Please ask for: Ms Iqraa Malik
Email: iqraa.malik@terraquest.co.uk
Telephone: 01212341390
Our Ref: FP/183/21/HH
Your Ref:
Date: 23rd August 2021

Application for Planning Permission for Works or Extension to a Dwelling

Development: New Porch Extension To Front Of Property
Location: 14 Sarisbury Close Felpham PO22 8JN

Block Plan.

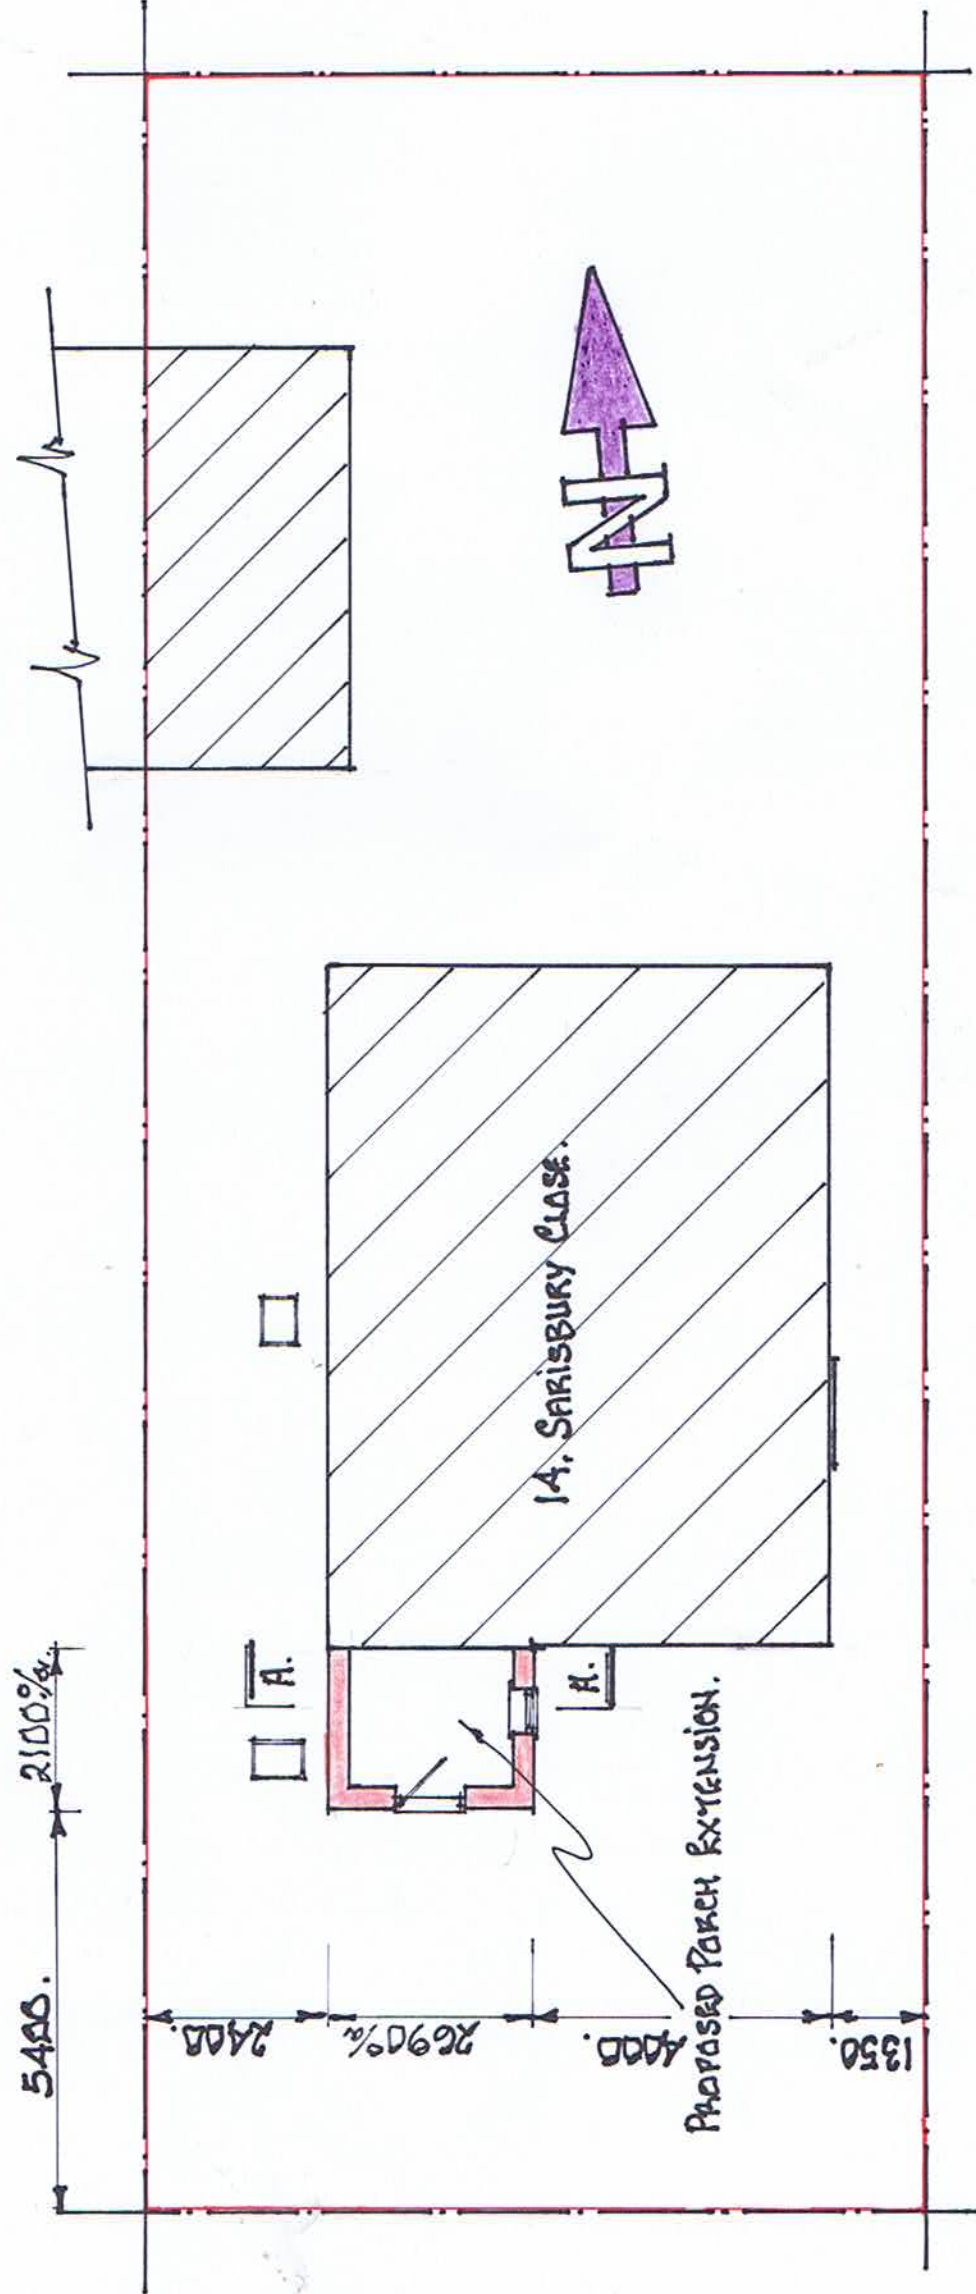
Block Plan

You are required to have dimensions from the proposed extension(s) to all site boundaries. Please amend.

Proposed Ground Floor Plan.

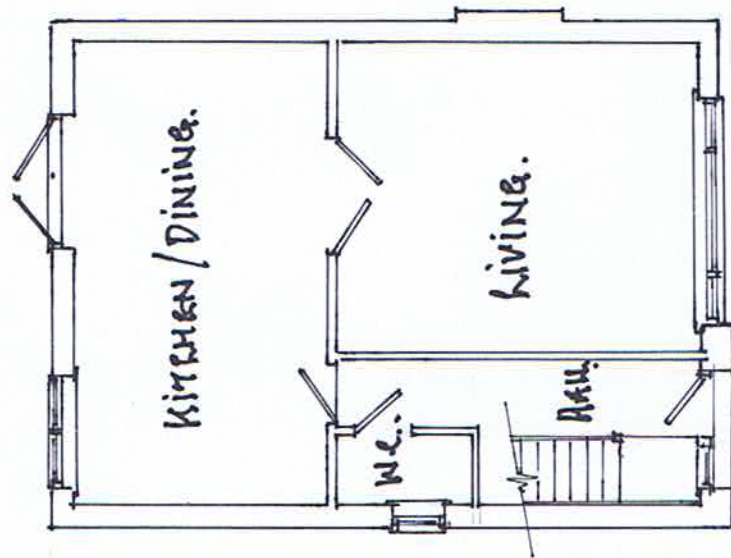
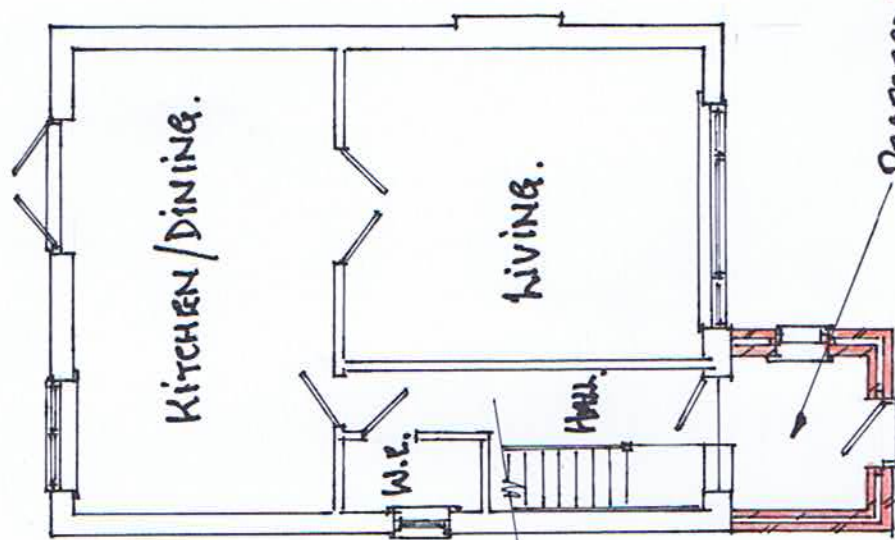
Floor Plans

Please submit clearly labelled existing and proposed ground floor plans at a scale of 1:50 or 1:100. Further details can be found in the Validation Requirements List.
